EPC STORMWATER REVIEW COMMENTS  
IN ORANGE BOXES WITH BLACK TEXT

# Crawford Apartments

# Grading & Erosion

# Control Plans

**C1.1**

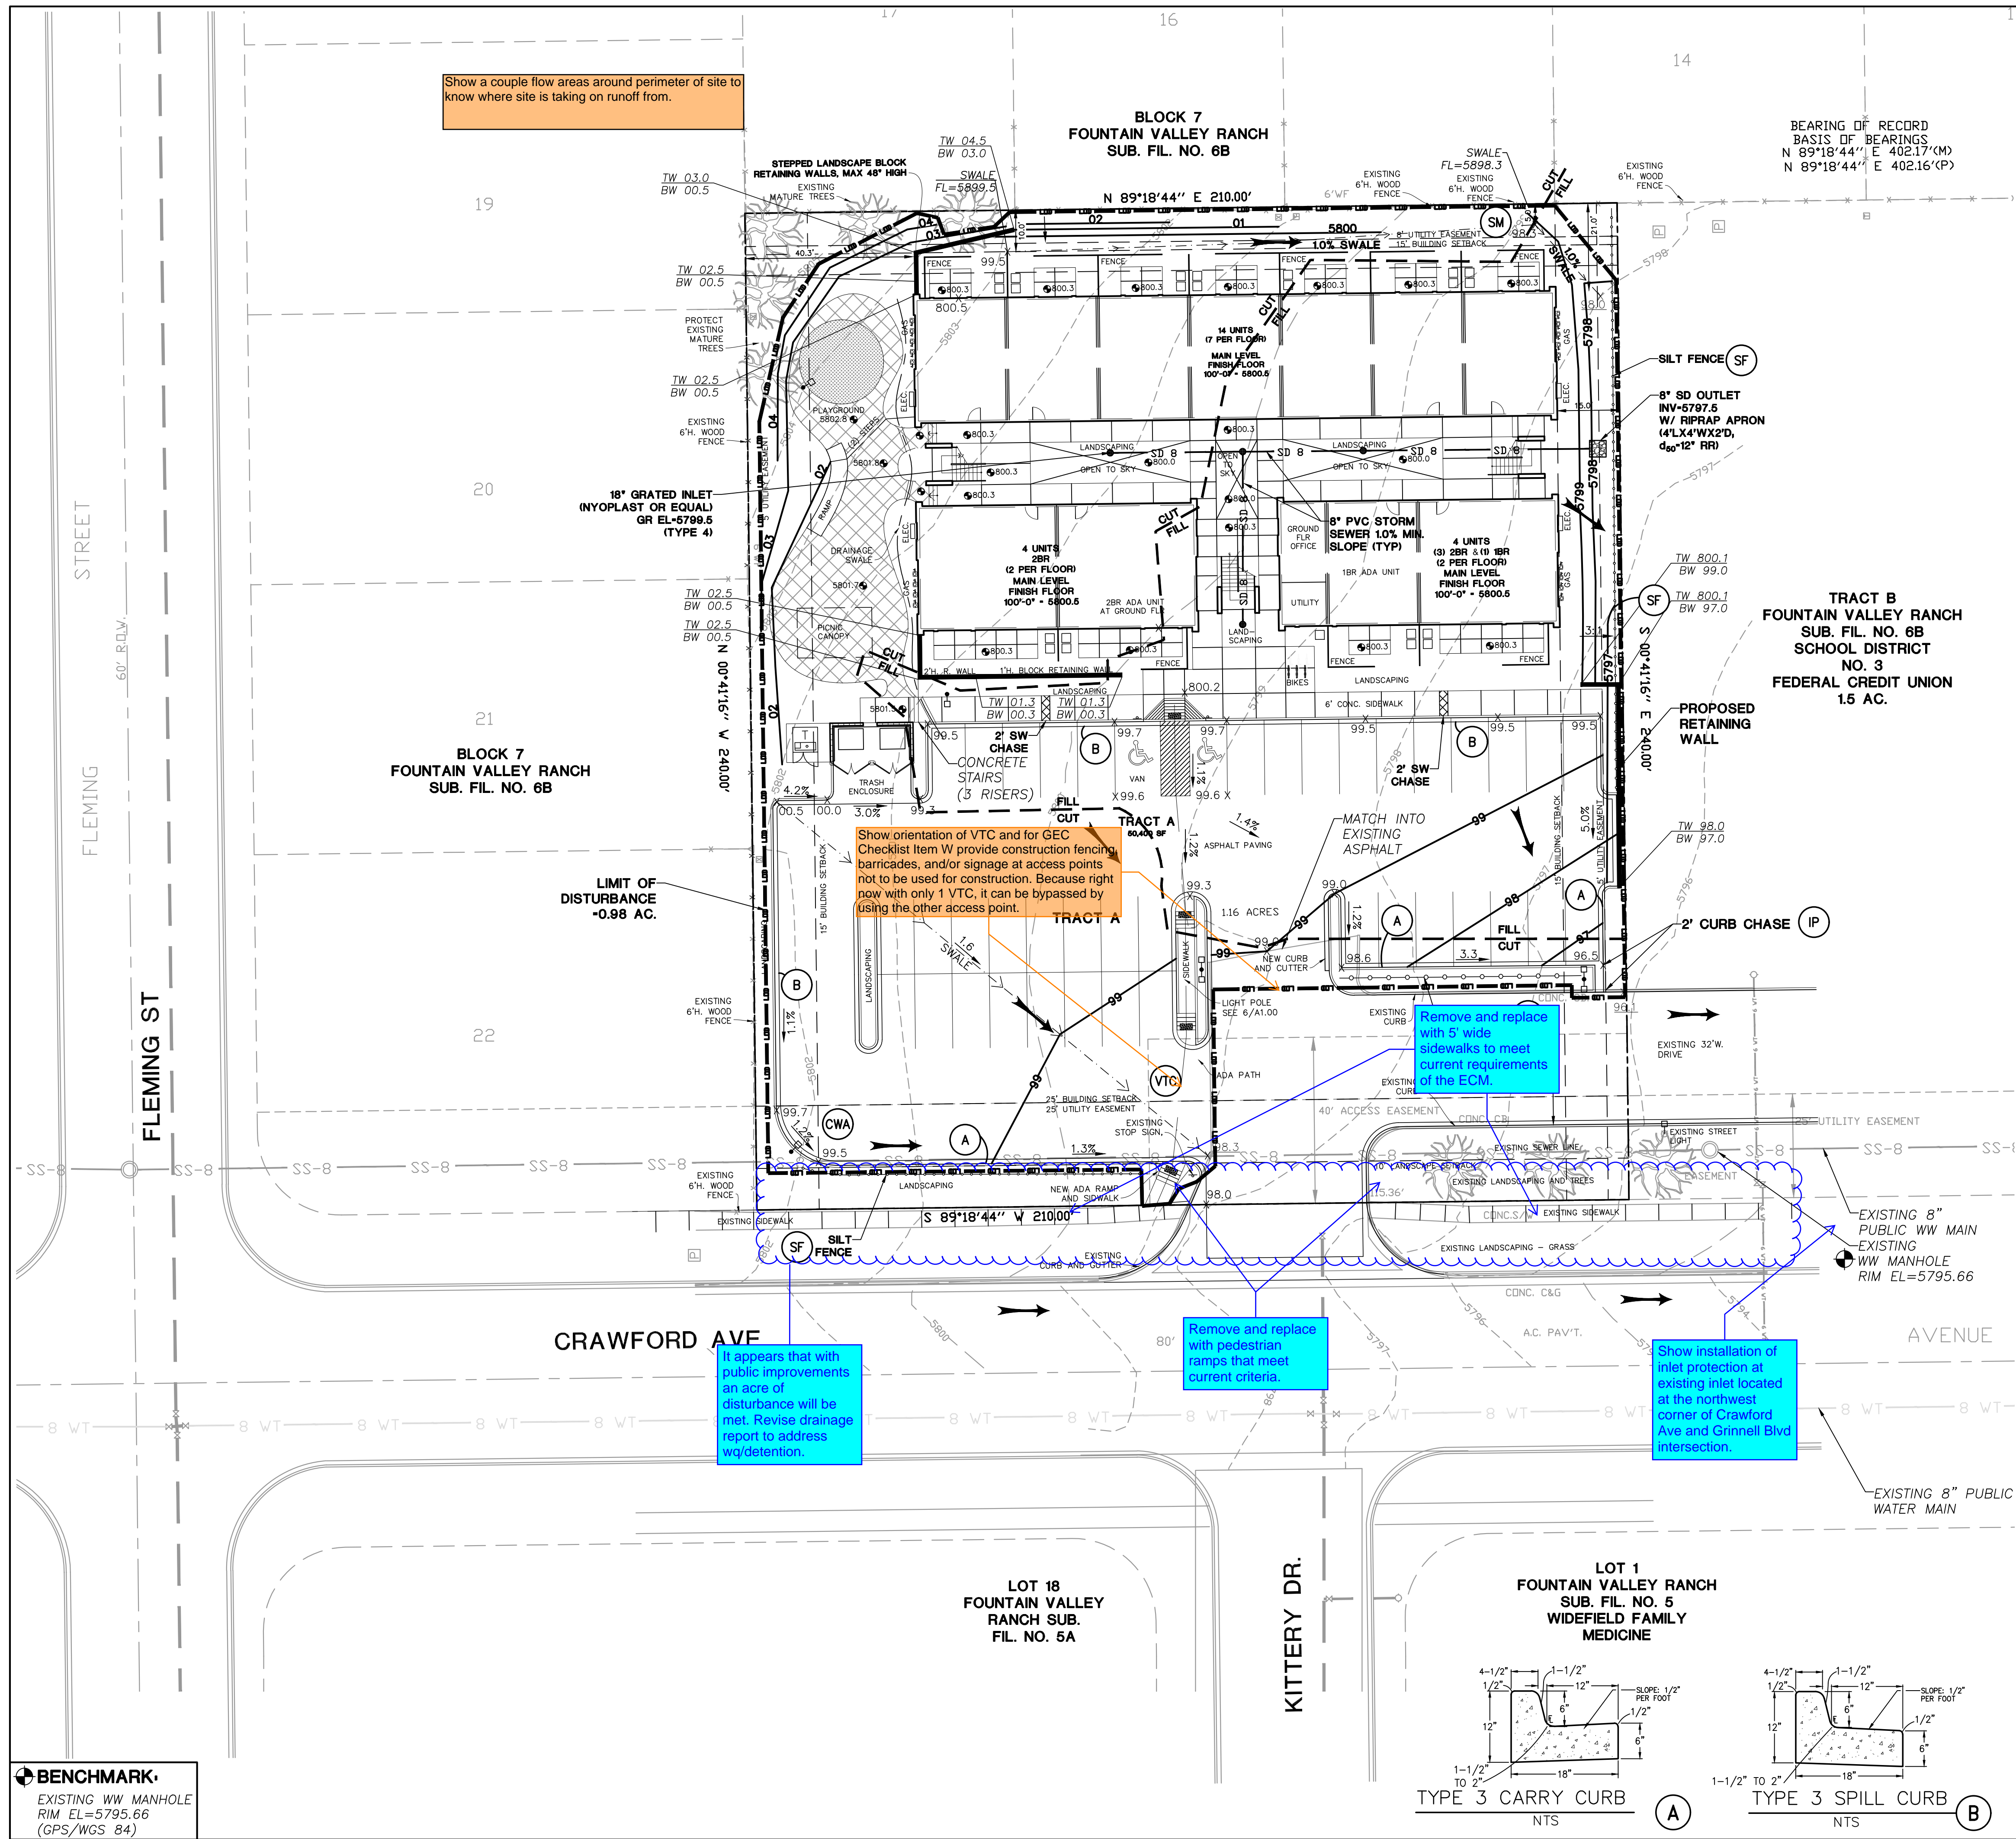
Show a couple flow areas around perimeter of site to know where site is taking on runoff from.

show swale contours or provide typical cross section. Is this swale interim or final condition?

call out finished material

show swale contours or provide typical cross section. Is this swale interim or final condition?

Show orientation of VTC and for GEC Checklist item W provide construction fencing, barricades, and/or signage at access points not to be used for construction. Because right now with only 1 VTC, it can be bypassed by using the other access point.

proposed or existing landscape? proposed landscaping must be included in LOD.

show swale contours or provide typical cross section

include hatching to clearly identify limits of permanent seeding/mulching

Remove and replace with 5' wide sidewalks to meet current requirements of the ECM.

It appears that with public improvements an acre of disturbance will be met. Revise drainage report to address wq/detention.

Remove and replace with pedestrian ramps that meet current criteria.

Show installation of inlet protection at inlet located at the northwest corner of Crawford Ave and Grinnell Blvd intersection.

Note: TSB is required for 1+ac of disturbance. Provide details of temporary sediment basin including riser pipe diameter and perforation sizing, number of rows of holes, required volume, location of outlet pipe and spillway, and tributary area to the sediment basin. And provide contours for sediment basin.
